2 December 2025

REF: WTJ24 -549

**RE: AMENDMENT TO SSD-80018208 – PROPOSED DATA CENTRE
PROPERTY AT 6-8 JULIUS AVENUE, NORTH RYDE (LOT 89 DP1082131)**

4 DA GFA LEVEL 03 PLAN
1:500

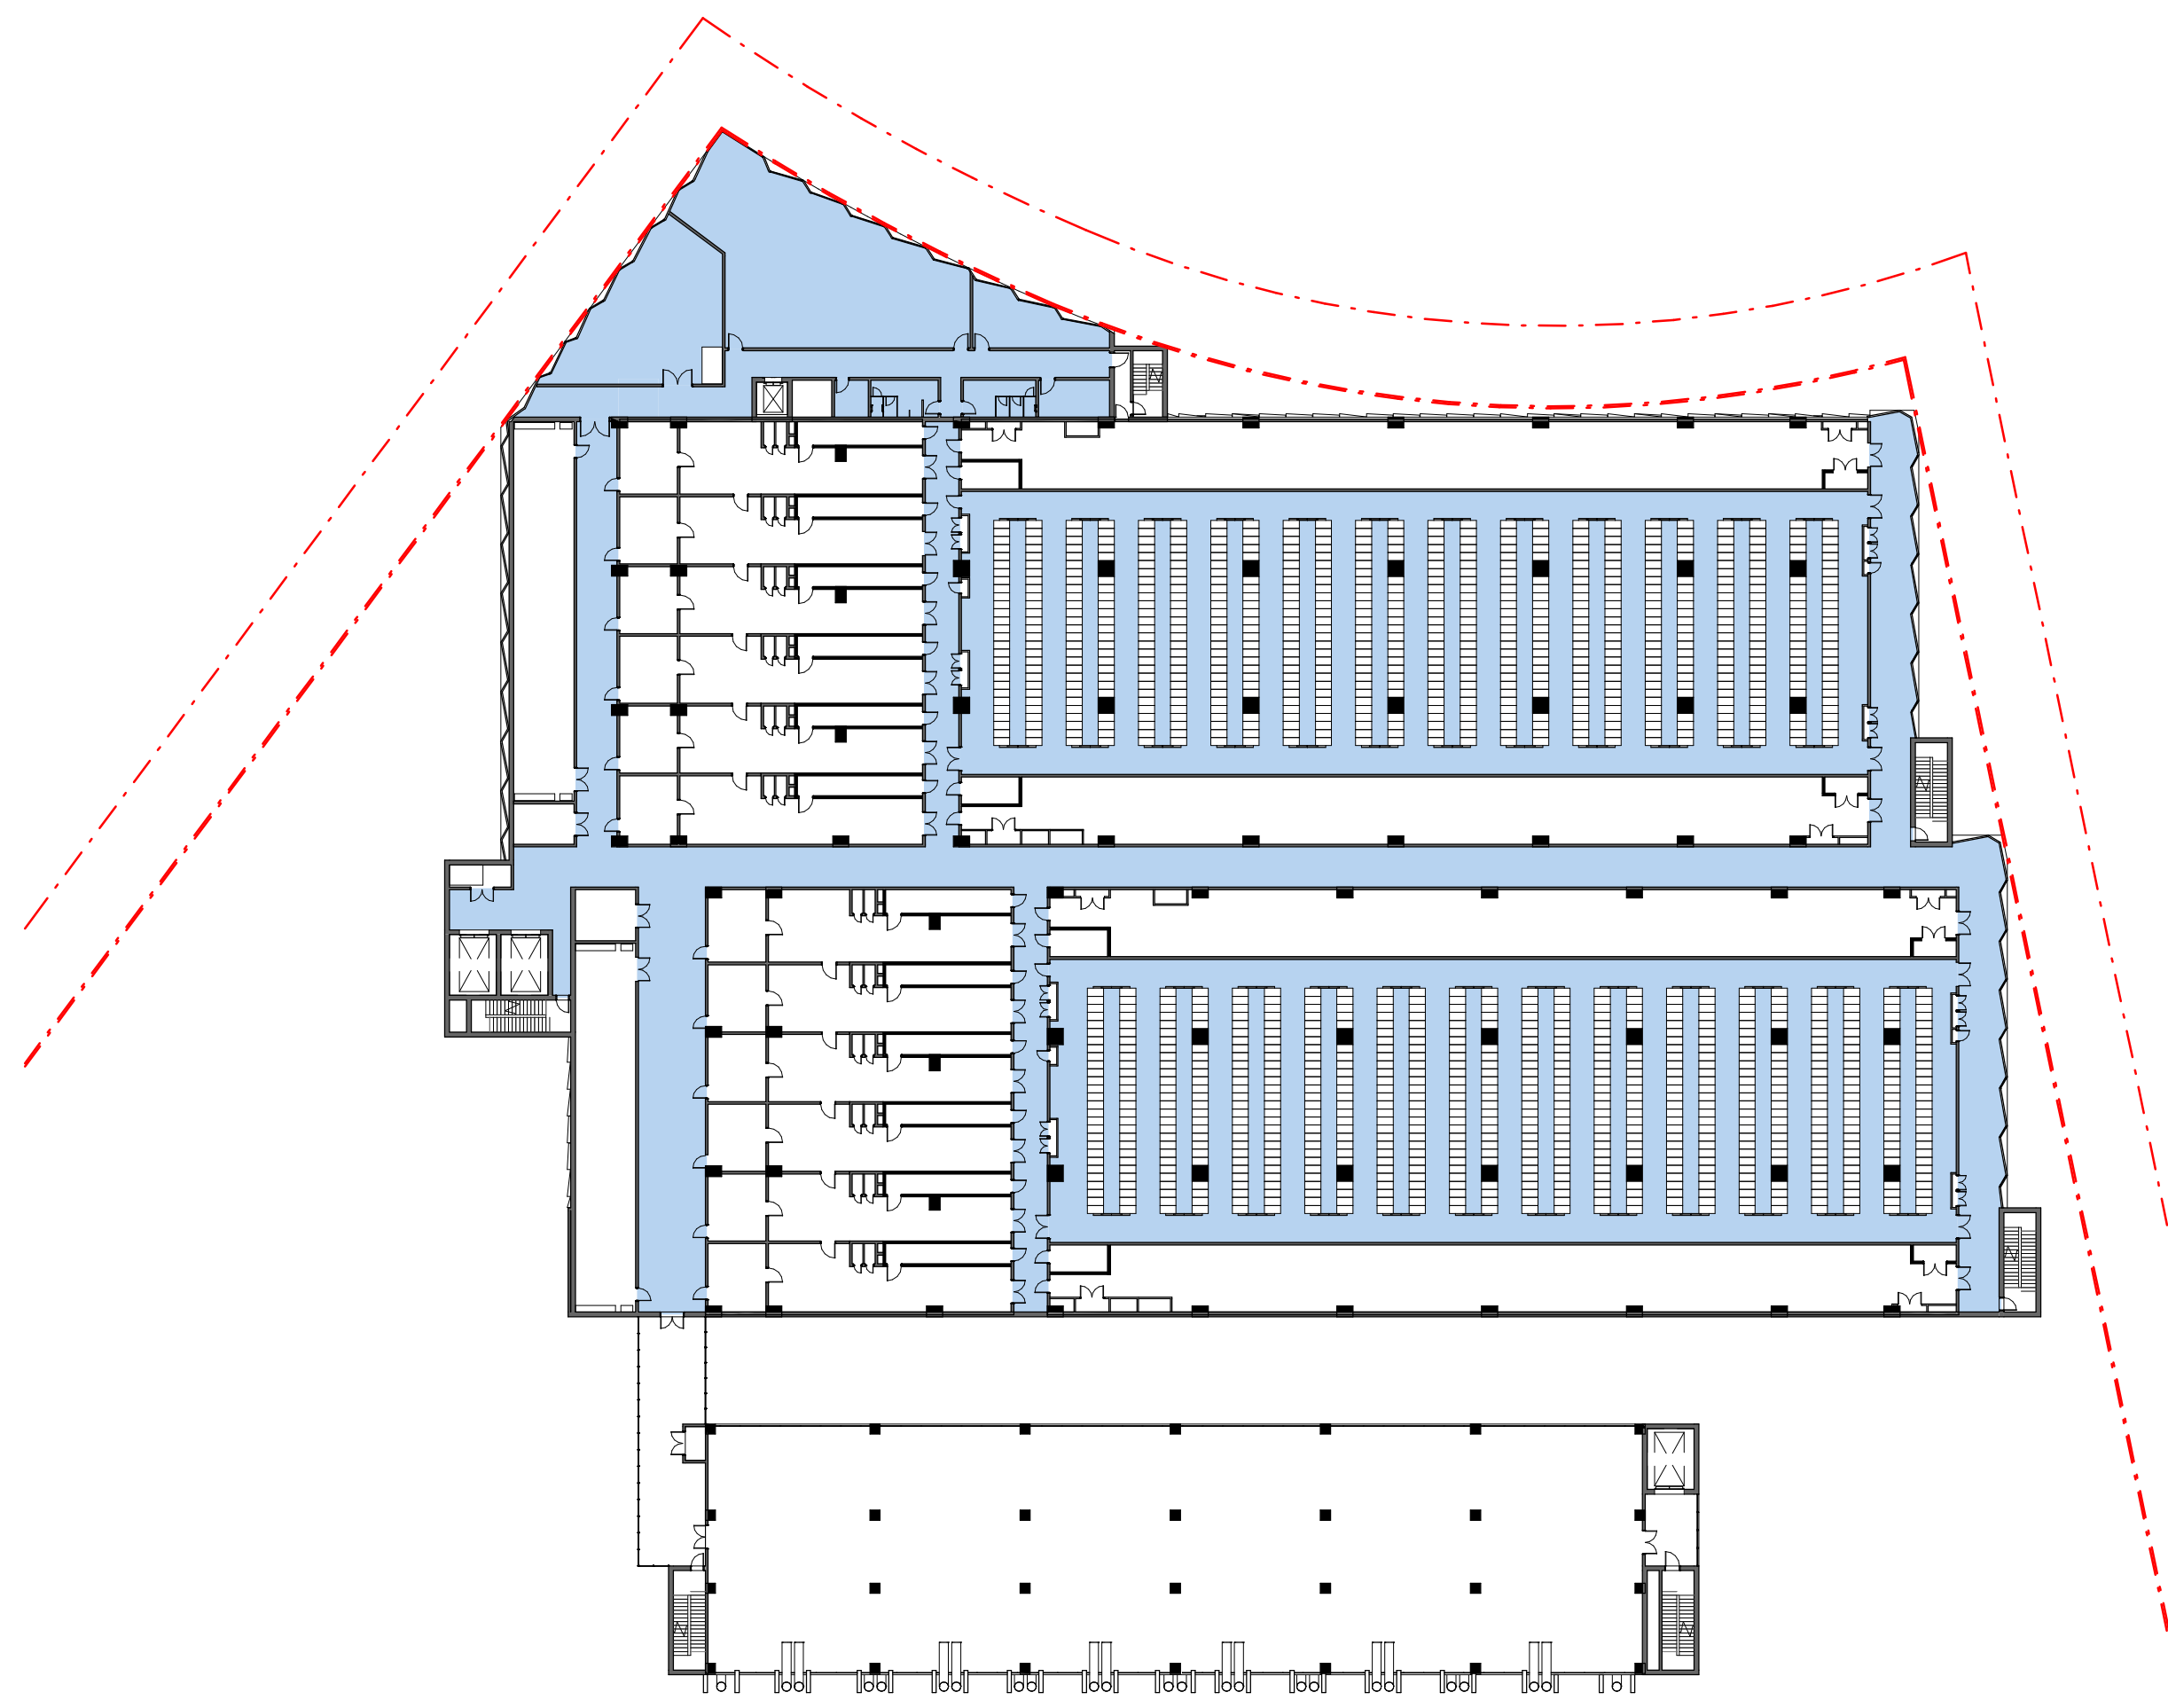
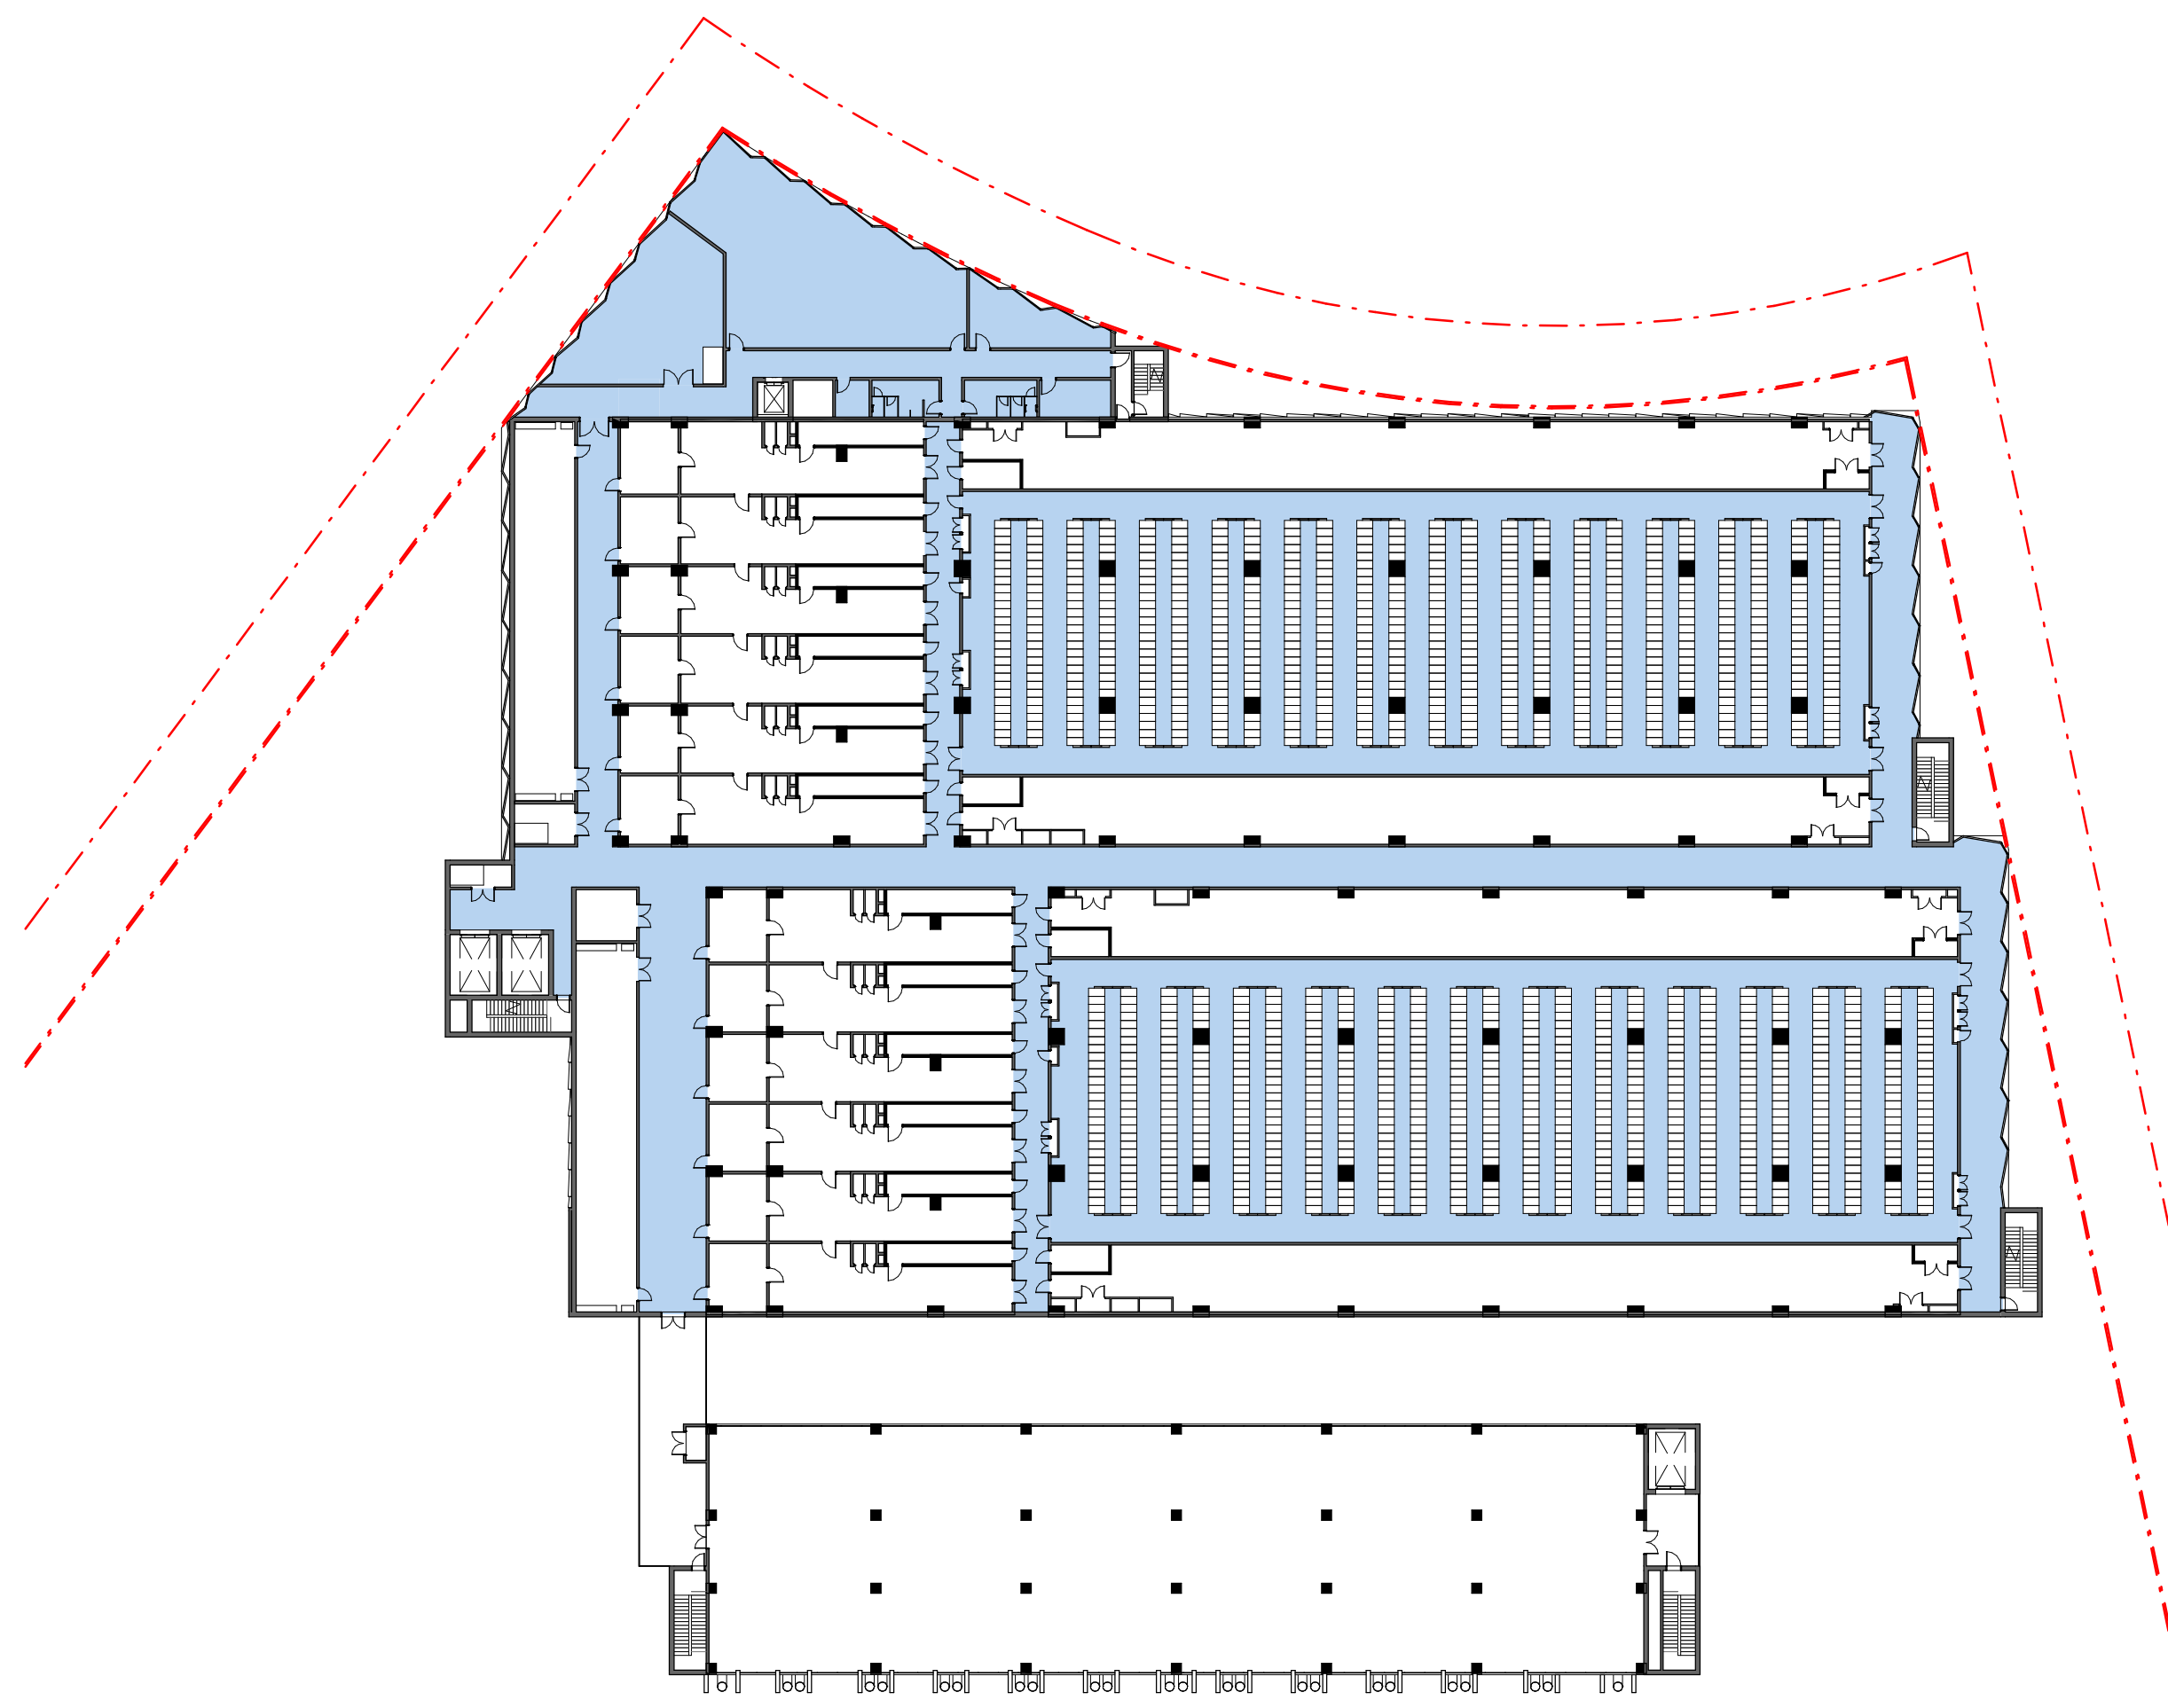
The development now has a reduced facility capacity (approximately 76MW, from 115.2MW) thus reducing consumption demands. Further, an amendment to the cooling methods of the facility has been proposed, with an adoption of air-cooled chillers, rather than the water-cooled chillers previously included. **TABLE 1** below summates the changes to operational measures of the proposed development.

TABLE 1. PROPOSED CHANGES		
Item	Previously Proposed	Proposed Through Amendment
Capacity	115.2MW	76MW, a reduction of approximately 34%.
Cooling Method	Water-cooled chiller level with rooftop cooling towers.	Single rooftop level comprising of air-cooled chillers.
Number of Storeys	6 storeys	4 storeys
Gross Floor Area (GFA)	26,076m ²	16,647m ²
Car parking	Basement level	Ground level

A reduction in capacity and the change to cooling methods allows the deletion of the former Level 6 chiller and deletion of the former basement level (as water storage tanks are no longer required).

Basement car parking has been relocated to the ground level adjacent to the proposed loading dock. As the site is zoned E3 under the RLEP 2014, Clause 6.7 applies, restricting ground floor development to commercial activities, and parking would be inconsistent with this requirement. The City of Ryde highlighted this technicality and provided advice that the parking is at ground level but not perceivable from street level due to the site's topography, and is therefore considered acceptable. The site has undergone major earthworks, with the actual ground floor situated more than 12 metres below Julius Avenue and aligning with the existing cut level.
